# Modification of Development Consent

**Application No:** SSD 6078

**Development:** The staged construction and operation of three warehouse, distribution and freight transport facilities on lots 1C, 2B and 3 at Oakdale Central, Horsley Park, and the upgrade of Old Wallgrove Road between Milner Avenue and Lenore Drive

**Modification:** SSD 6078 MOD 11 – Amendments to the estate signage

SIGNAGE HIERARCHY	
Sign A	8.0m HIGH Site Identification
Sign B	3.5m HIGH Building Identification
Sign C	2.8m HIGH All Truck Entry
Sign D	2.1m HIGH All Car Entry
Sign E	2.1m HIGH All Pedestrian Entry

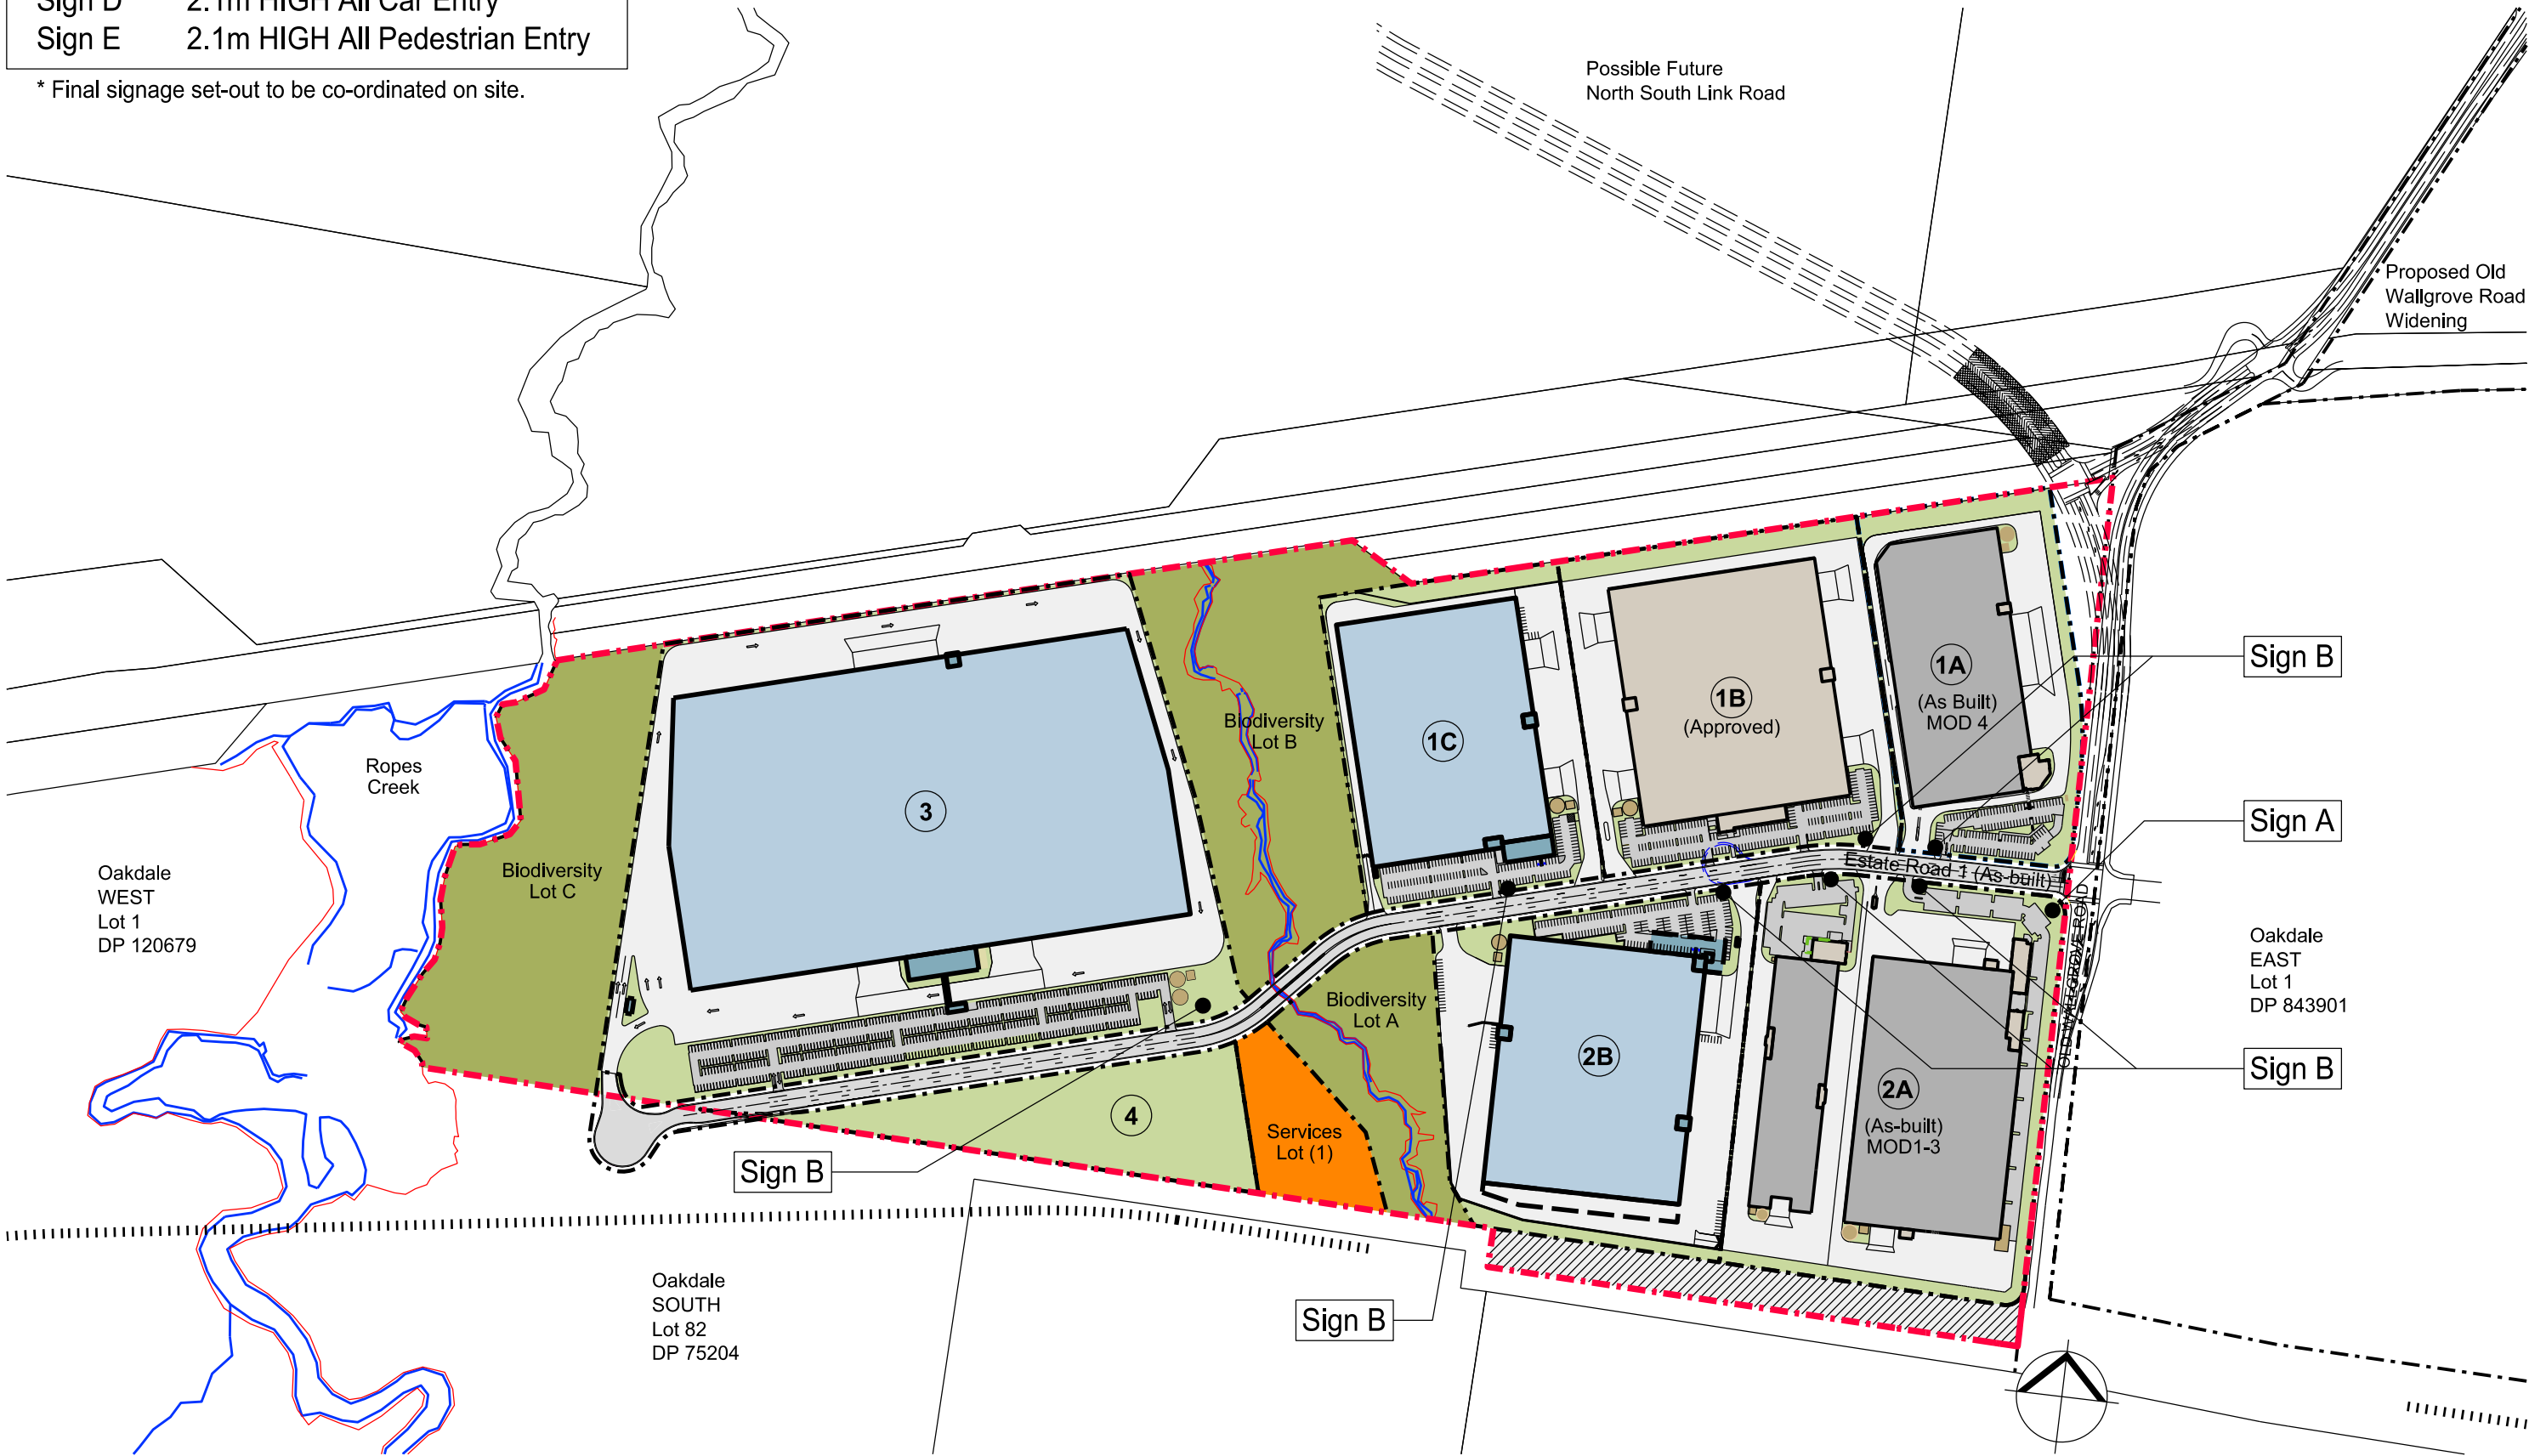
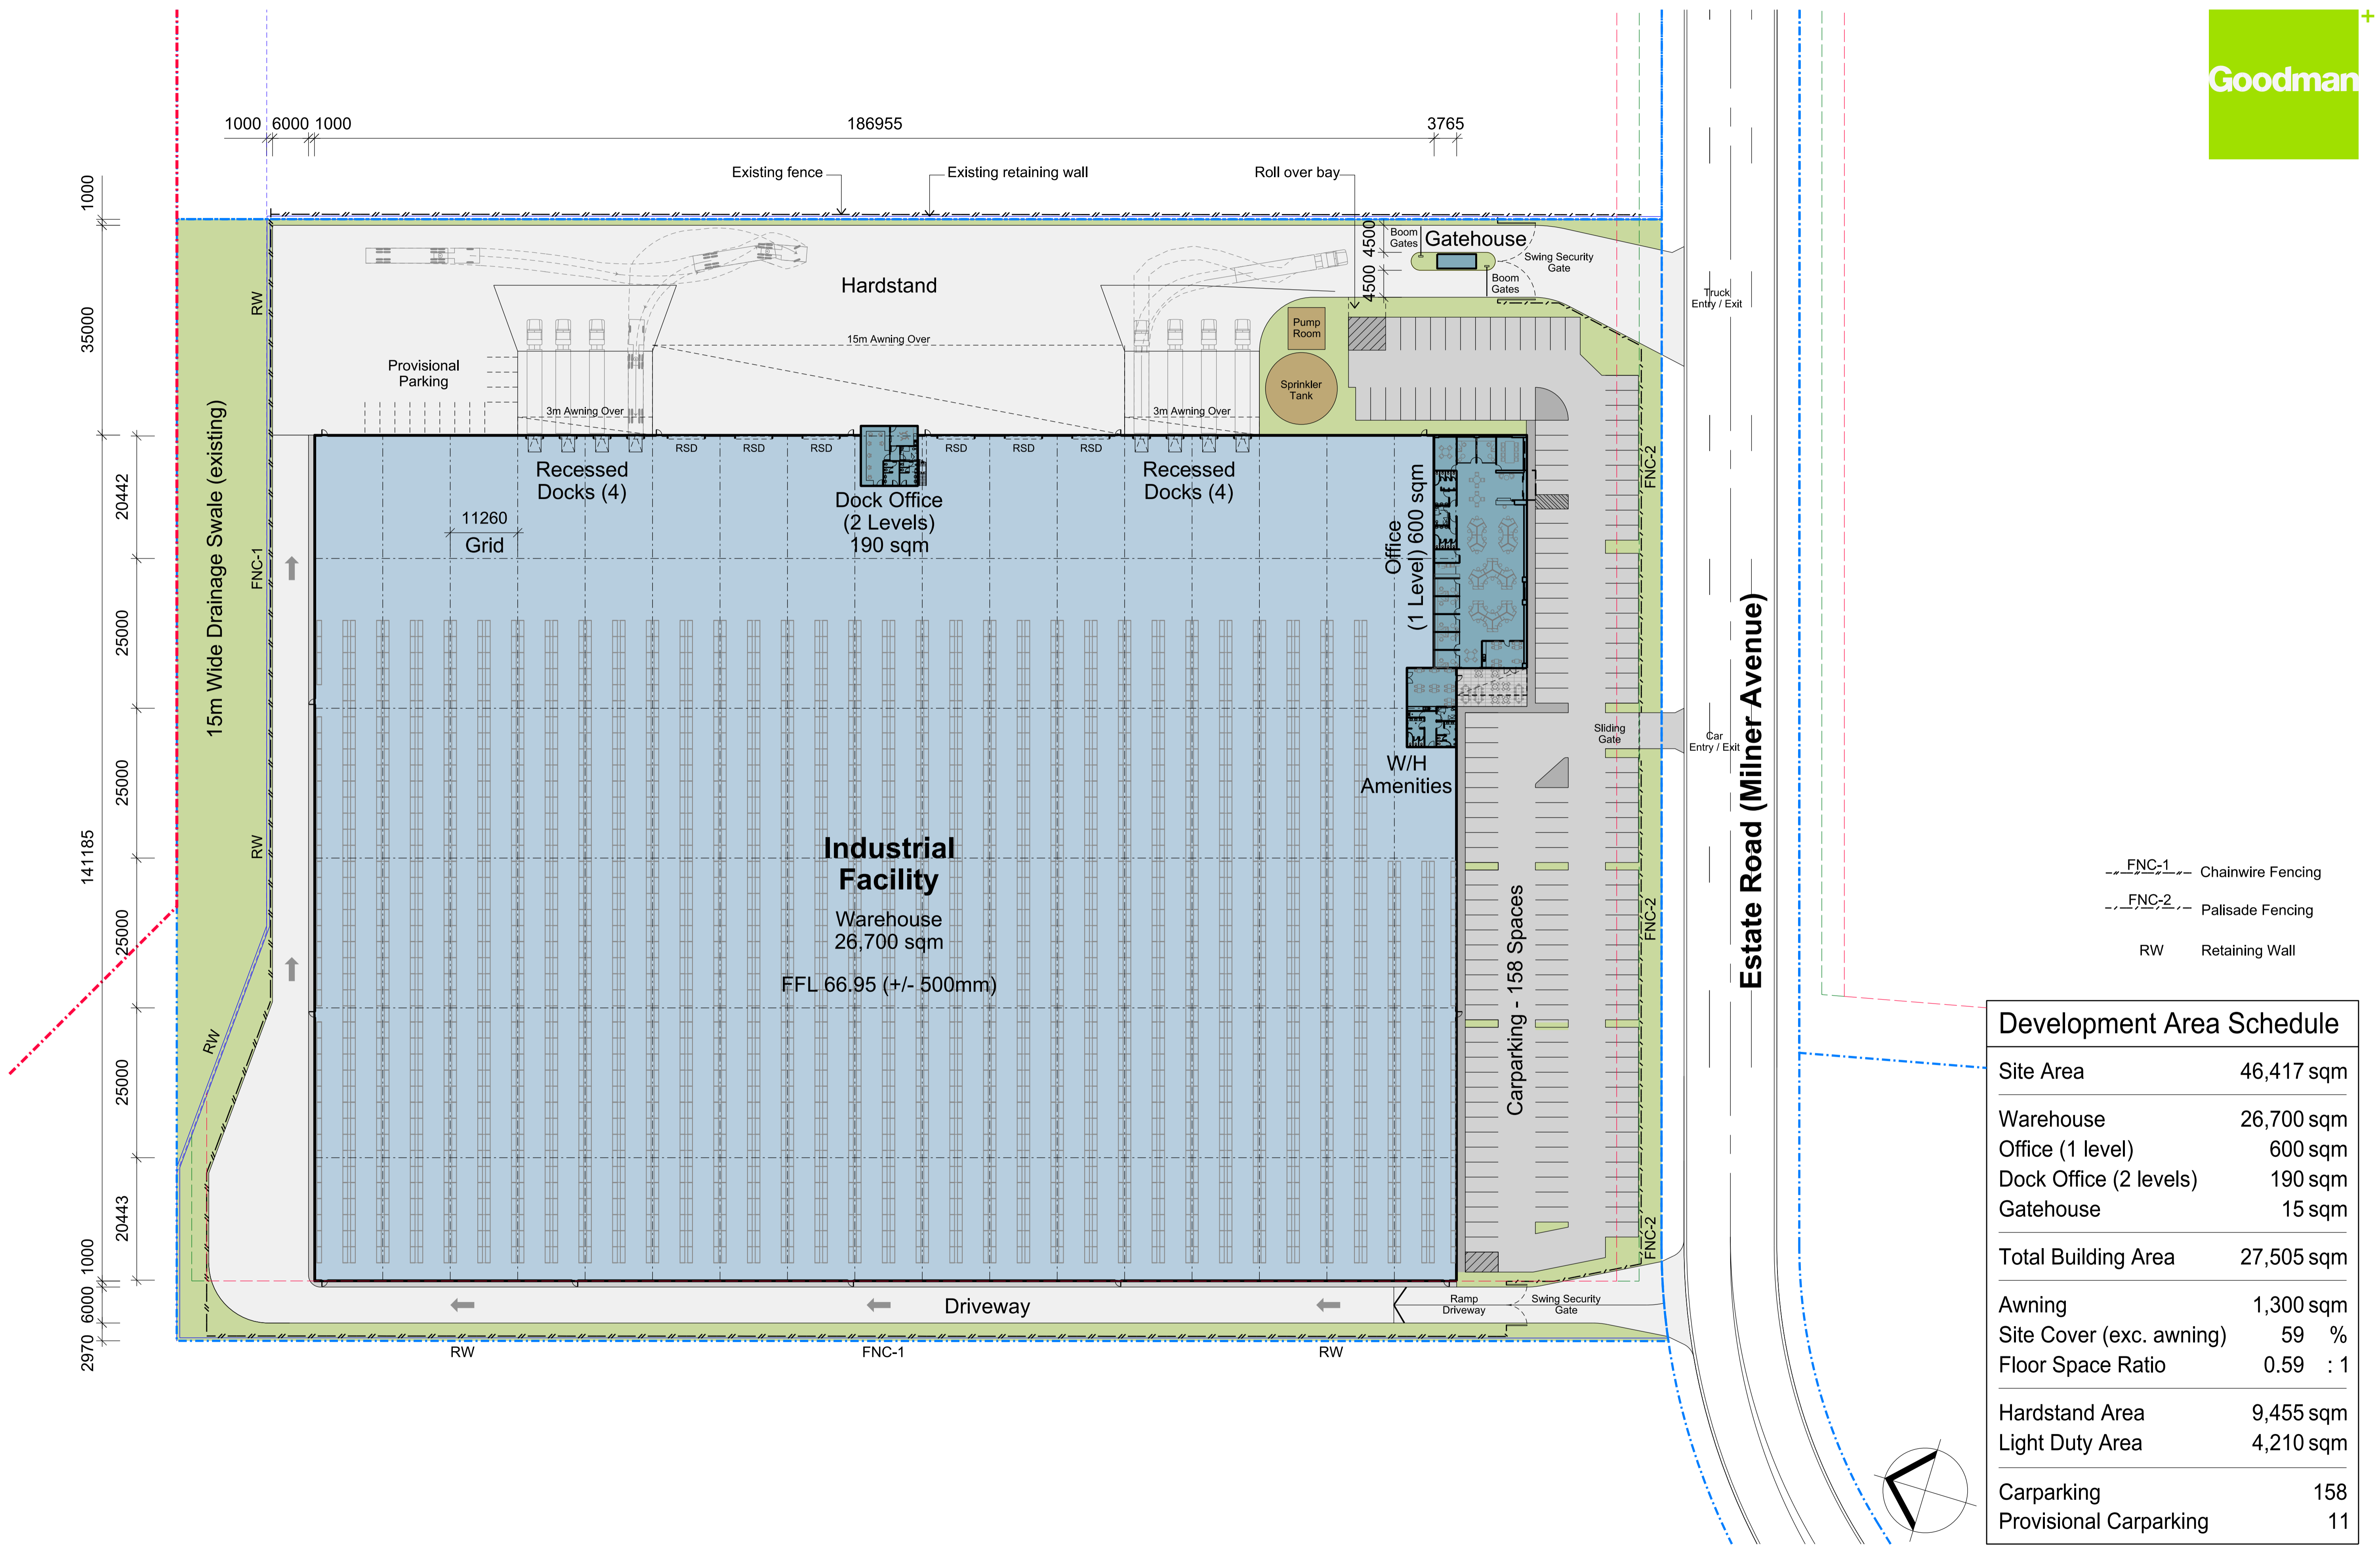
30. Prior to commencement of construction of any signage the following information must be submitted and approved by the Secretary:
- (a) detailed architectural drawings for the signs identified in the:
    - i. Estate Signage Plan OAK 3 DA 05 (R) dated 26 February 2018;
    - ii. Lot 3A – Site Plan/Floor Plan OAK 3 DA 30 (J) dated 11 January 2017;
    - iii. Lot 3C – Site Plan/Floor Plan OAK 3 DA 40 (U) dated 3 April 2017; and
    - iv. Lot 3D – Site Plan/Floor Plan OAK 3 DA 50 (H) dated 8 May 2017;
